January 21, 2020

Re: 10026 Central Ave SE
Project Address
Traffic Circulation Layout
Engineer's/Architect's Stamp 01-14-2020 (L20D073)

Based upon the information provided in your submittal received 01-14-2020, the above referenced plan cannot be approved for Building Permit until the following comments are addressed:

Sheet: TCL

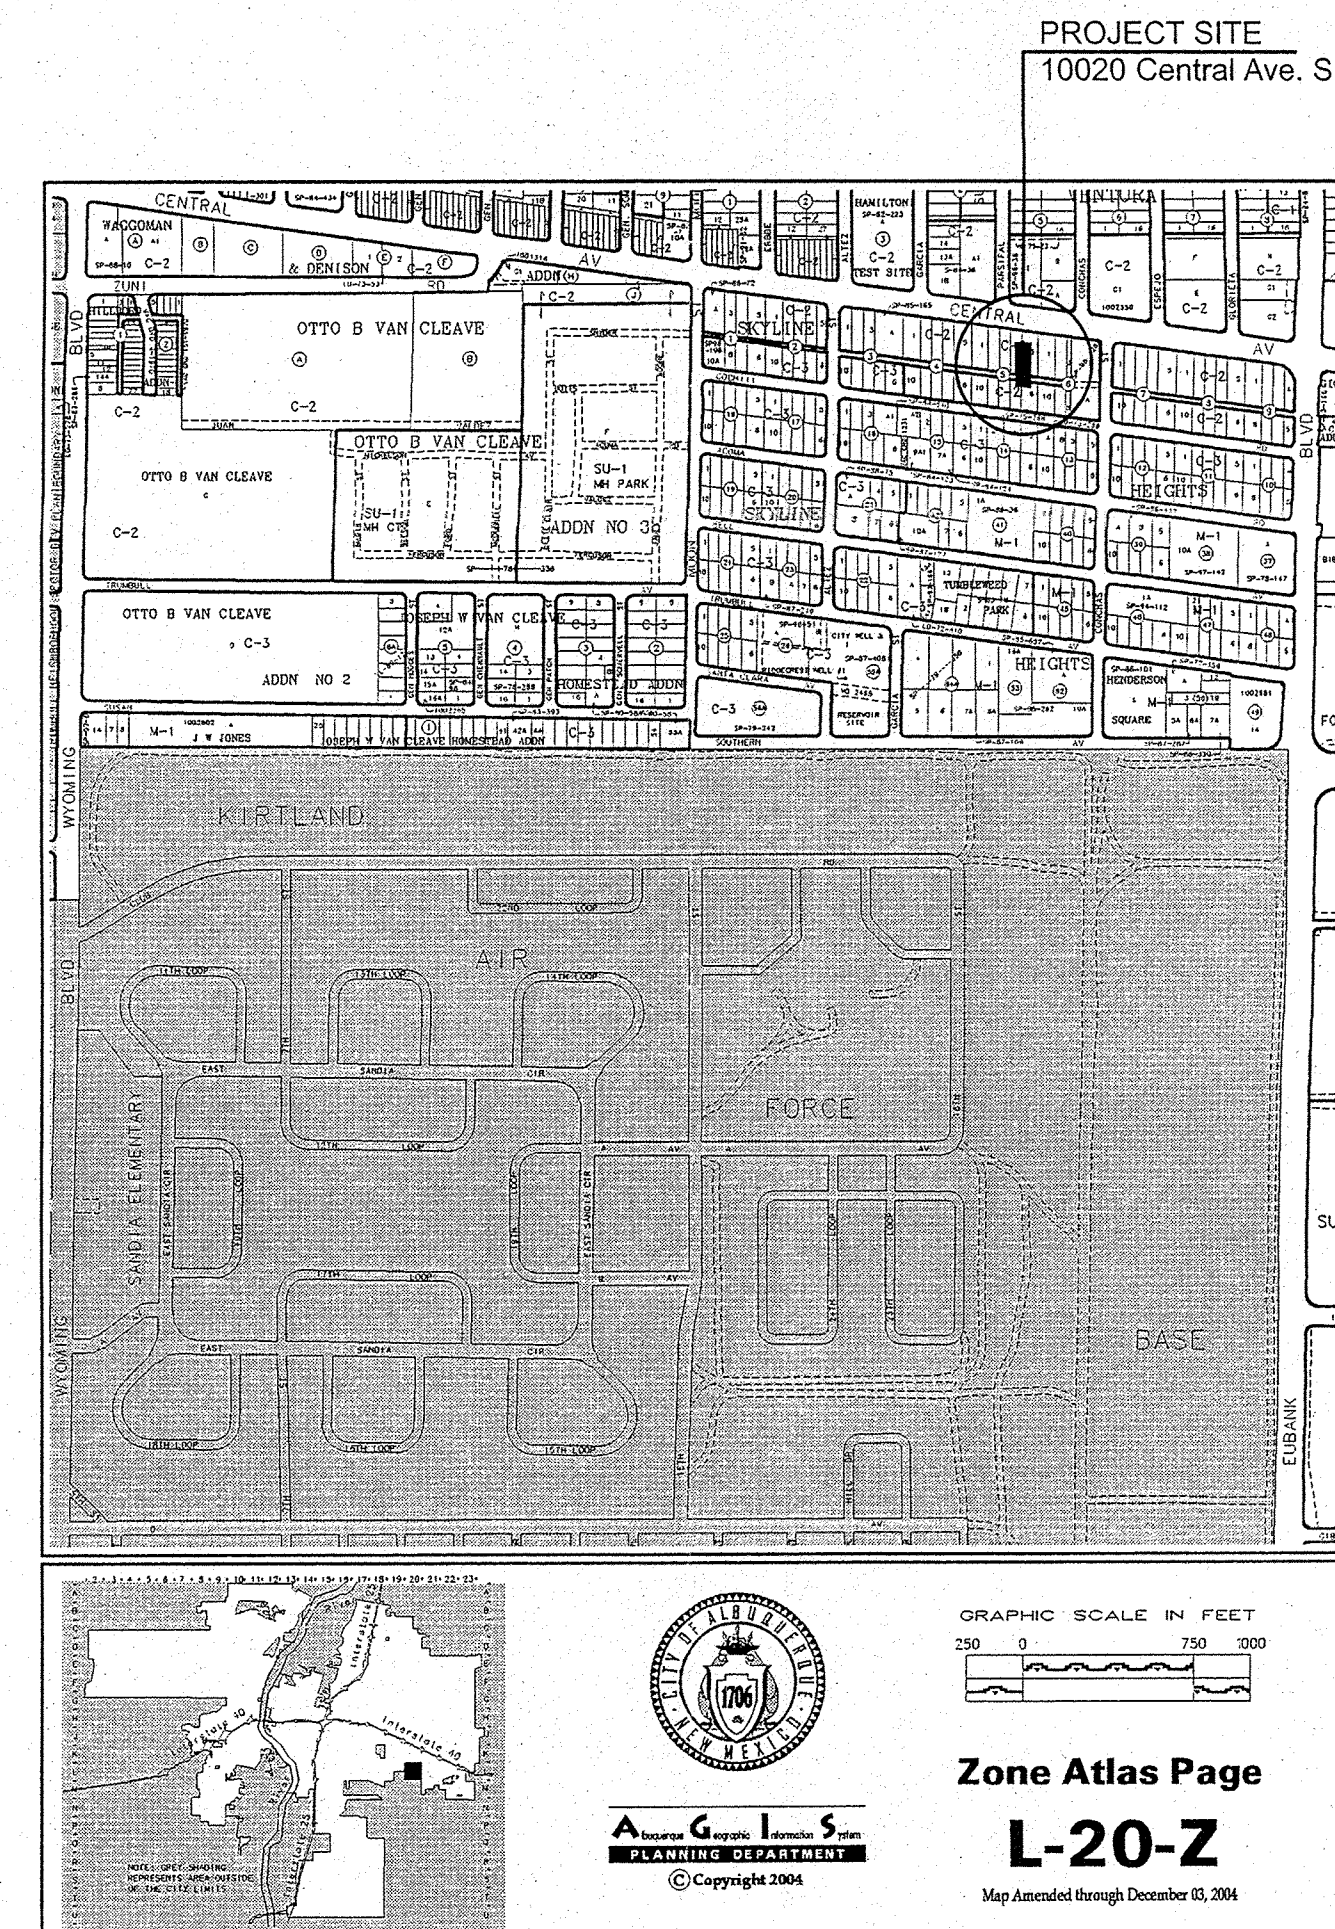
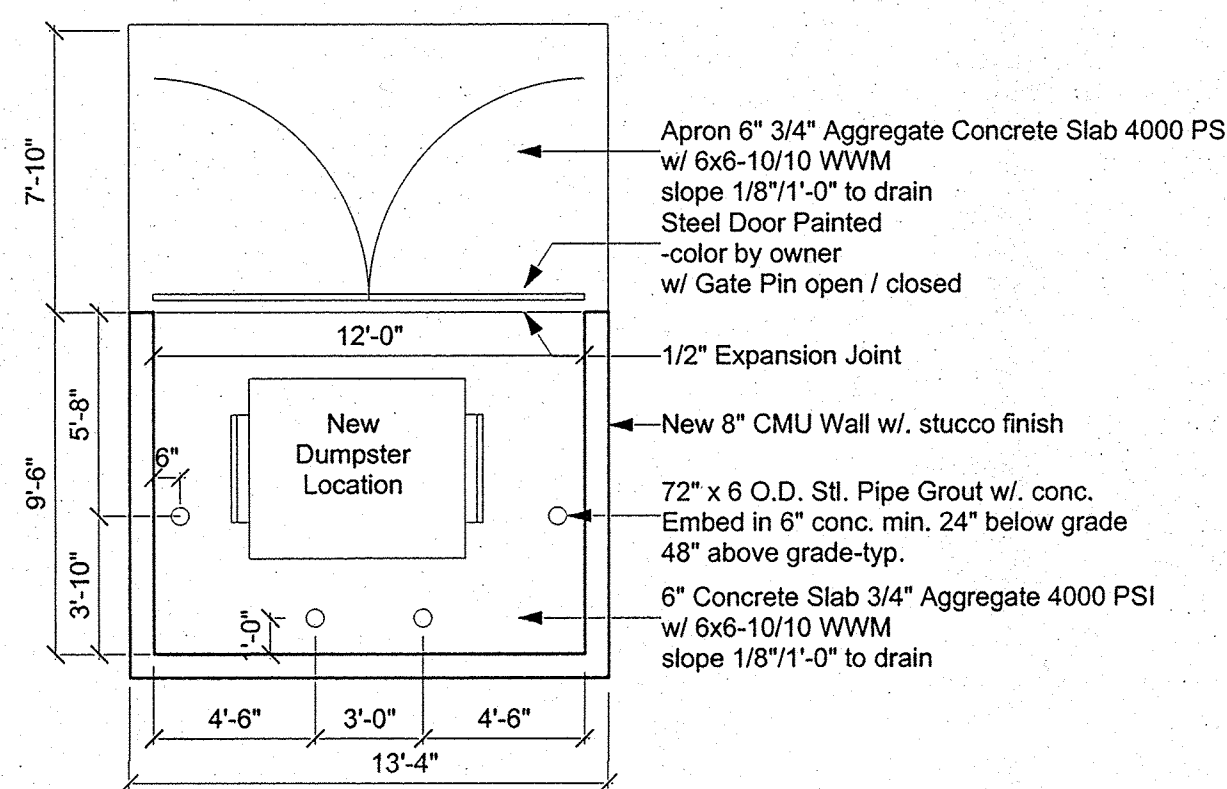
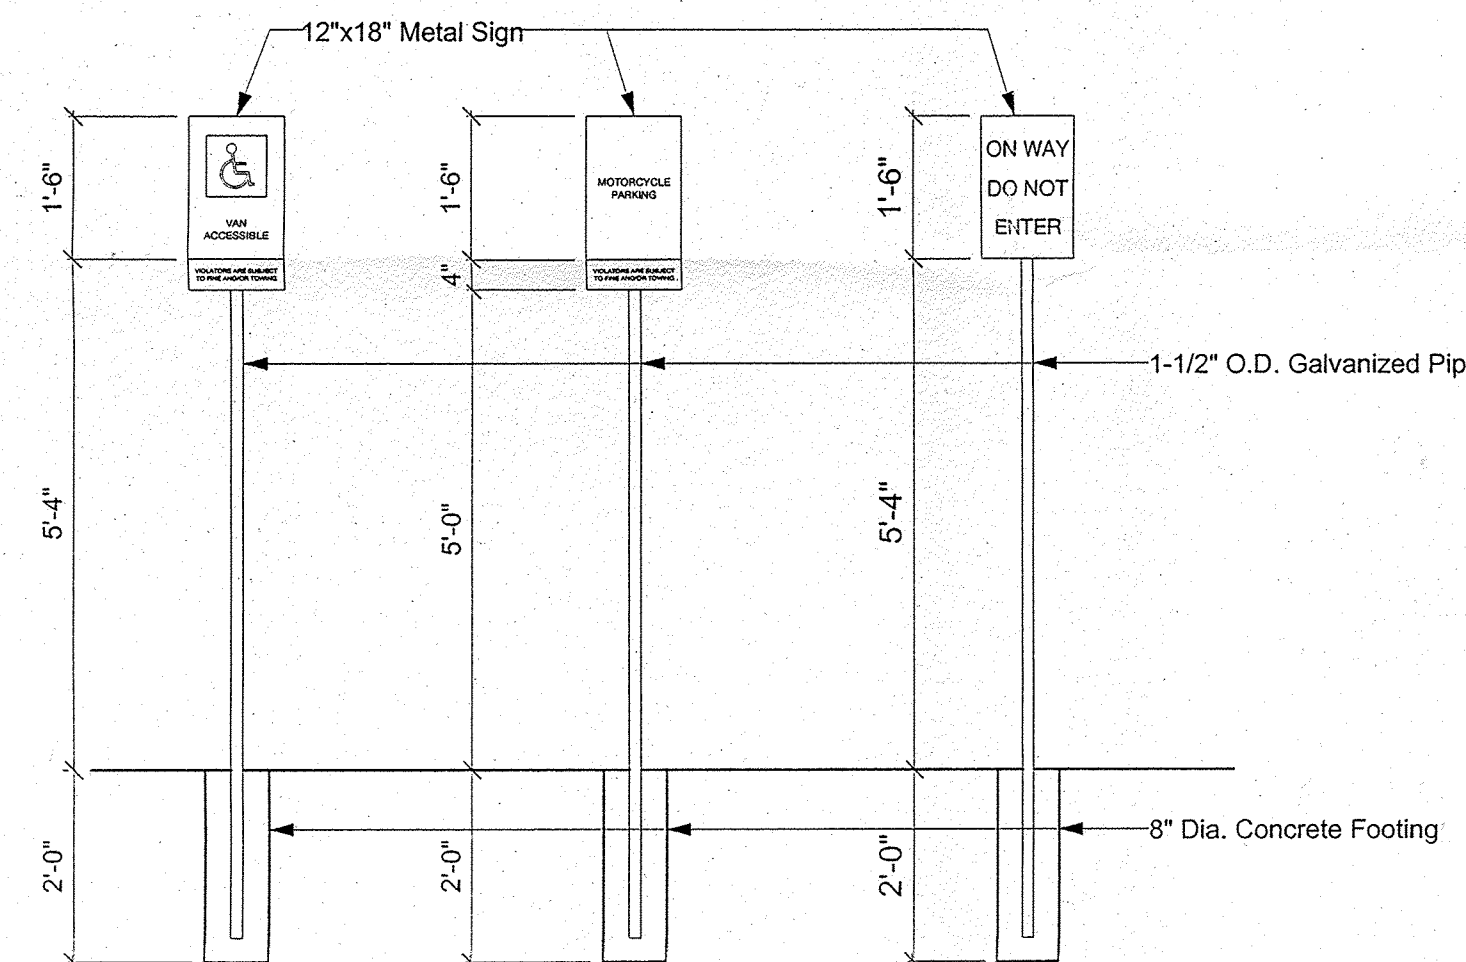
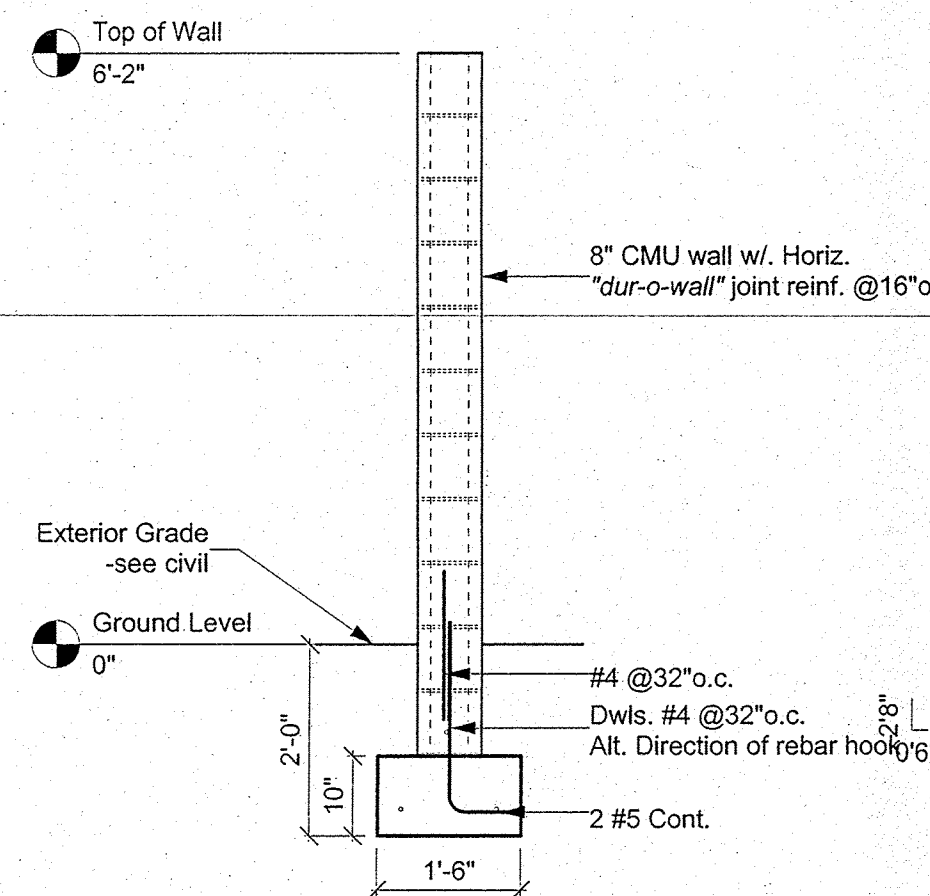
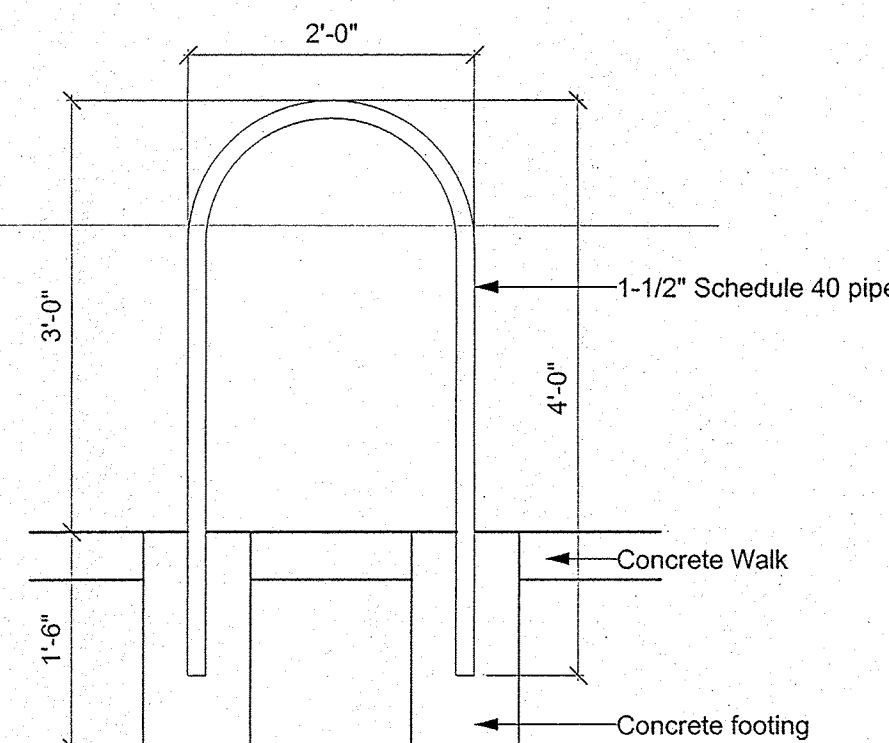
1. On the vicinity map, please identify the property.
2. Correct the address both on the DTIS form and on the site plan: 10020 Central Ave is not the correct address.
3. The scale must be shown on the plan. Per the Development Process Manual, Chapter 27, Section 2, Part B.1, on the following scales may be used:

1" = 20'	1" = 40'
1" = 50'	1" = 100' (for overall layouts only)
4. The ADA accessible parking sign must have the required language per 66-7-352.4C NMSA 1978 **"Violators Are Subject to a Fine and/or Towing."** Please call out detail and location of signs.

5. ADA curb ramps must be updated to current standards and have truncated domes installed.
6. Please call out the pedestrian pathway connection to the public sidewalk.

7. Refuse vehicle maneuvering shall be contained on-site. The refuse vehicle shall not back into the public right of way.; provide a copy of refuse approval.

8. It is not apparent what type of pavement surface is being proposed. A hard driving surface will be required as part of this proposed project for parking area and drive aisles.

9. All one-way drives shall have "One Way" and "Do Not Enter" signage and pavement markings. Please show detail and location of posted signs and striping.

10. Show the clear sight triangle and add the following note to the plan:
"Landscaping and signage will not interfere with clear sight requirements."

Therefore, signs, walls, trees, and shrubbery between 3 and 8 feet tall (as measured from the gutter pan) will not be acceptable in the clear sight triangle.

11. Shared Site access: driveways that straddle property lines, or are entirely on one property but are to be used by another property, shall have an access easement. Please include a copy of your shared access agreement with the adjacent property owner.
12. Add a note stating "All broken or cracked sidewalk must be replaced with sidewalk and curb & gutter." A build note must be provided referring to the appropriate City Standard drawing.
